Struthers Ranch Polaris Grading & Erosion Control Plans El Paso County, Colorado

STRUTHERS RANCH POLARIS
LOTS 1-2, STRUTHERS RANCH SUBDIVISION FILING NO. 4

GEC PLAN
TITLE SHEET

SITE PLAN
SCALE: 1"=30'-0"

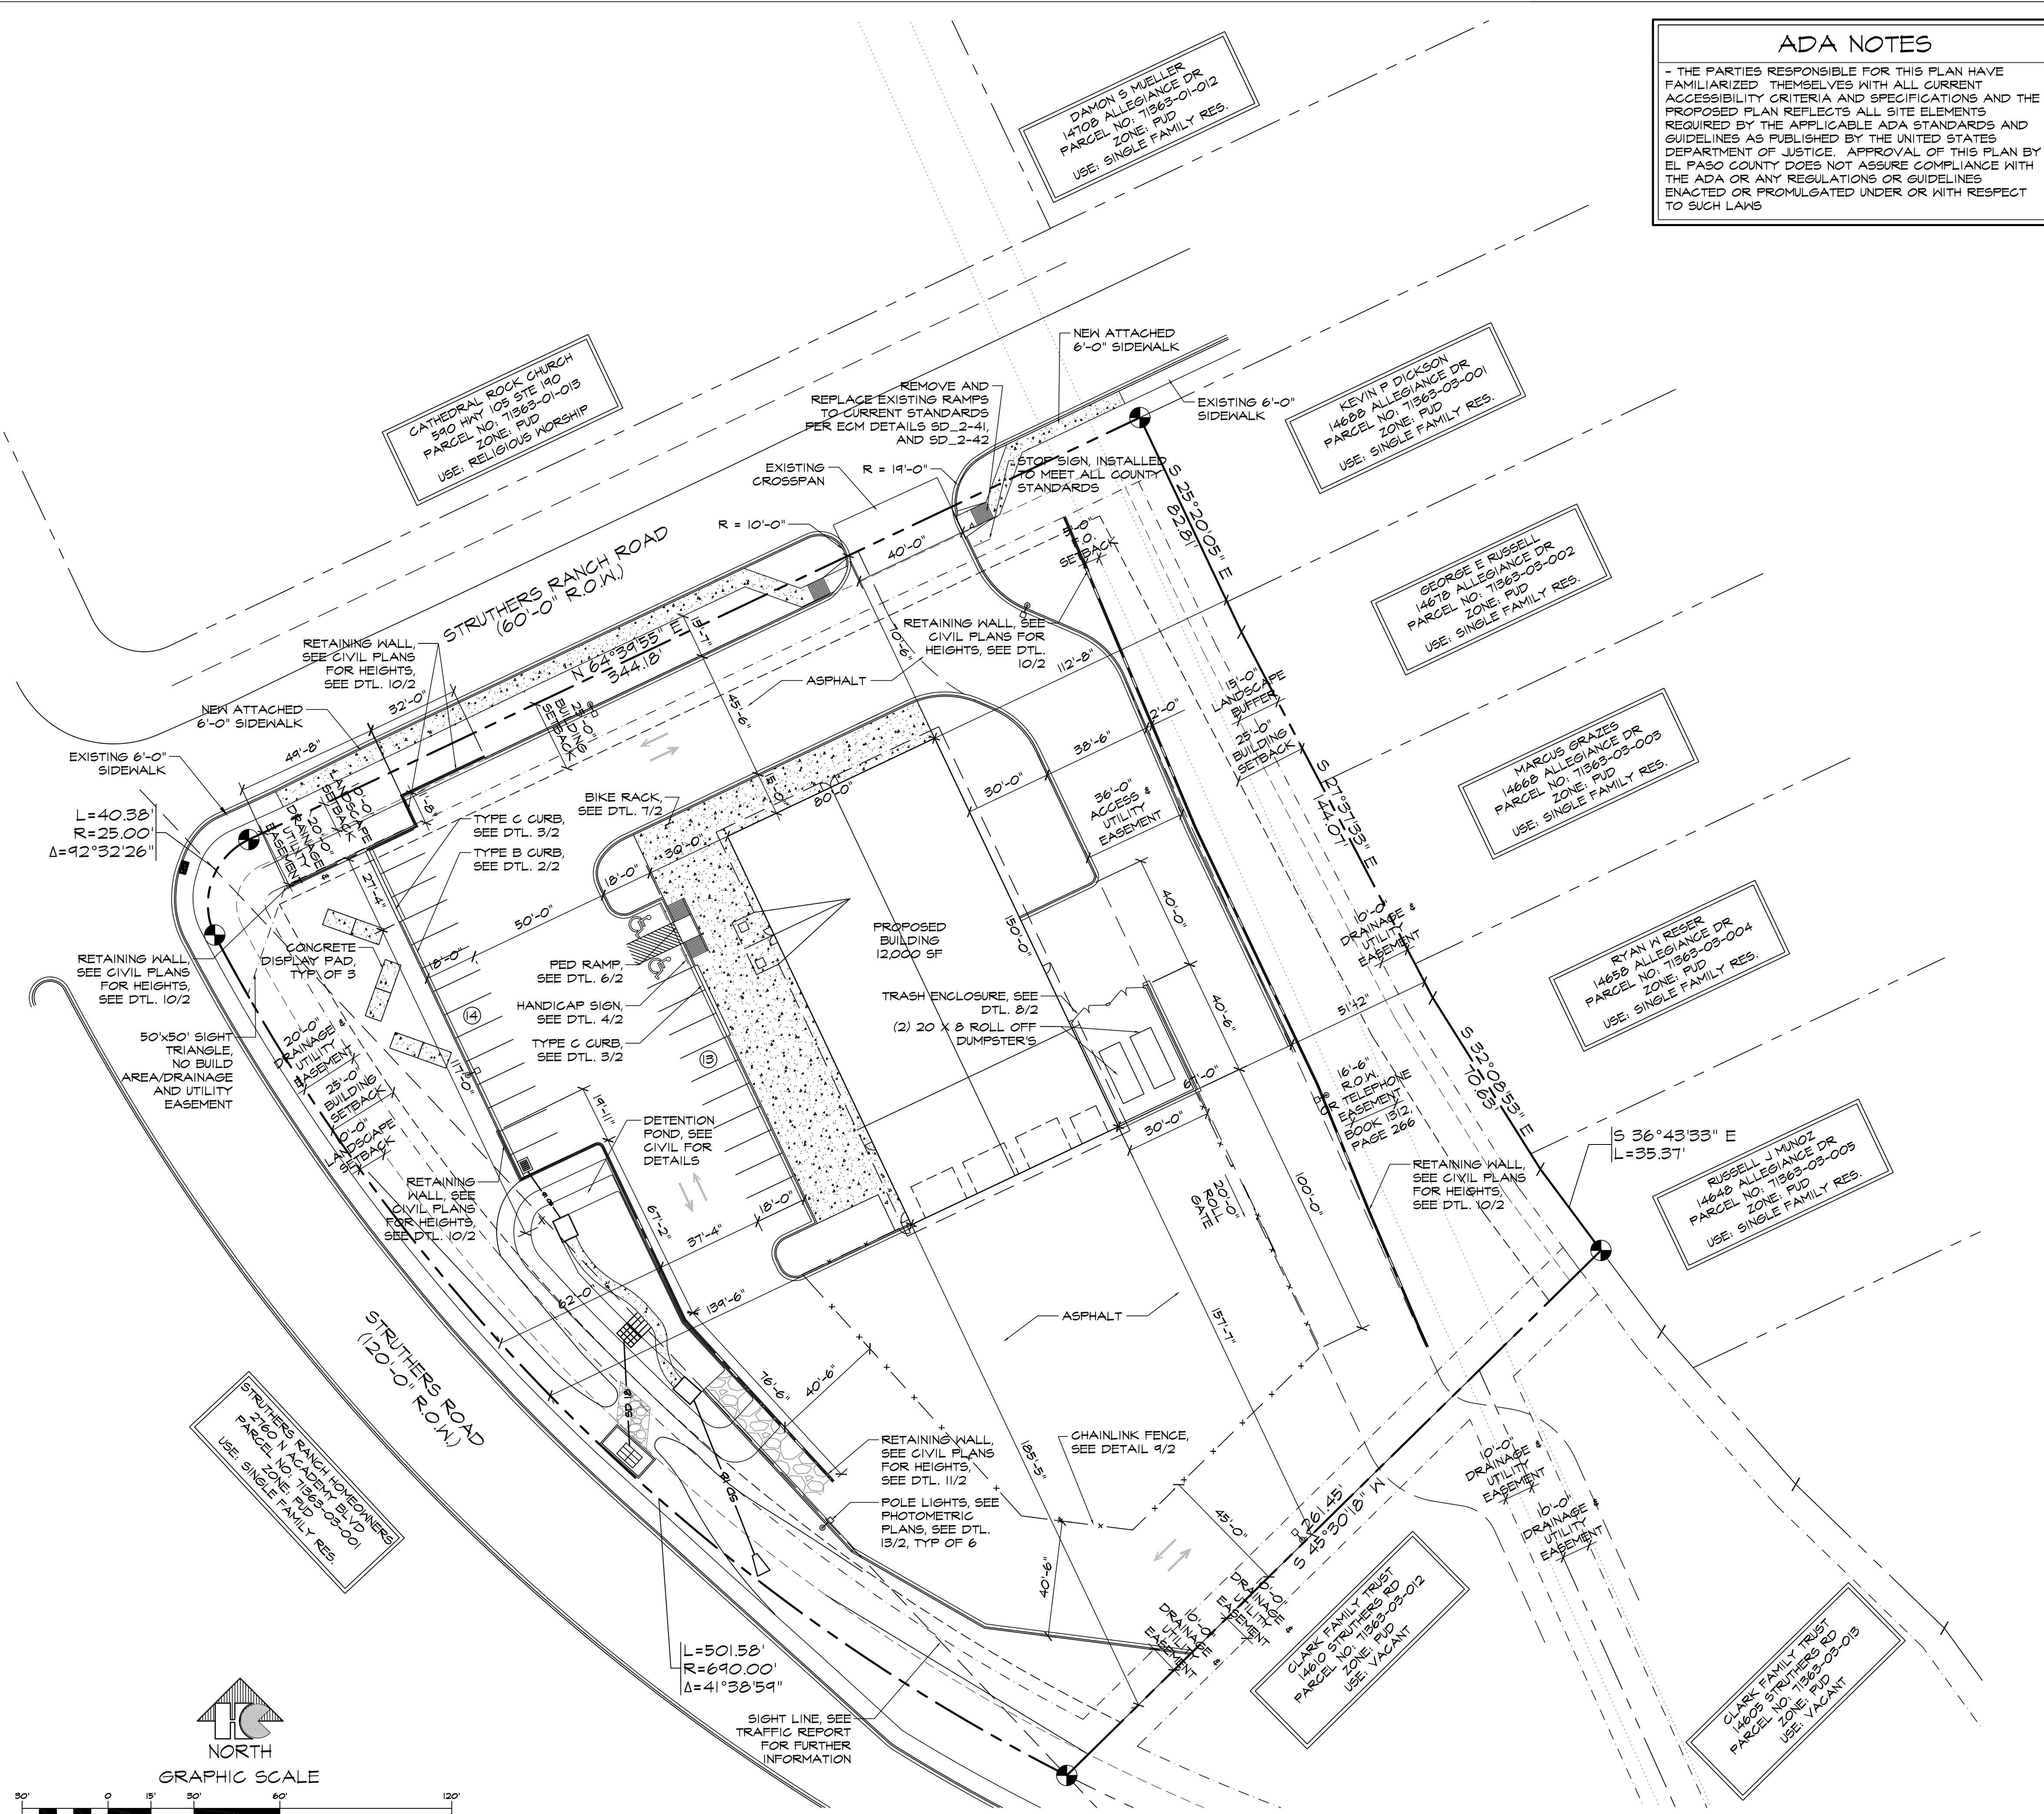
Unresolved. Show the line of sight (Blue line is approximate based on Bluebeam software measurement tool, Design engineer to show actual layout and not per the review markup)

Provide a profile along the line of sight showing the existing & proposed ground, and line of sight from driver's eye to object height per criteria.
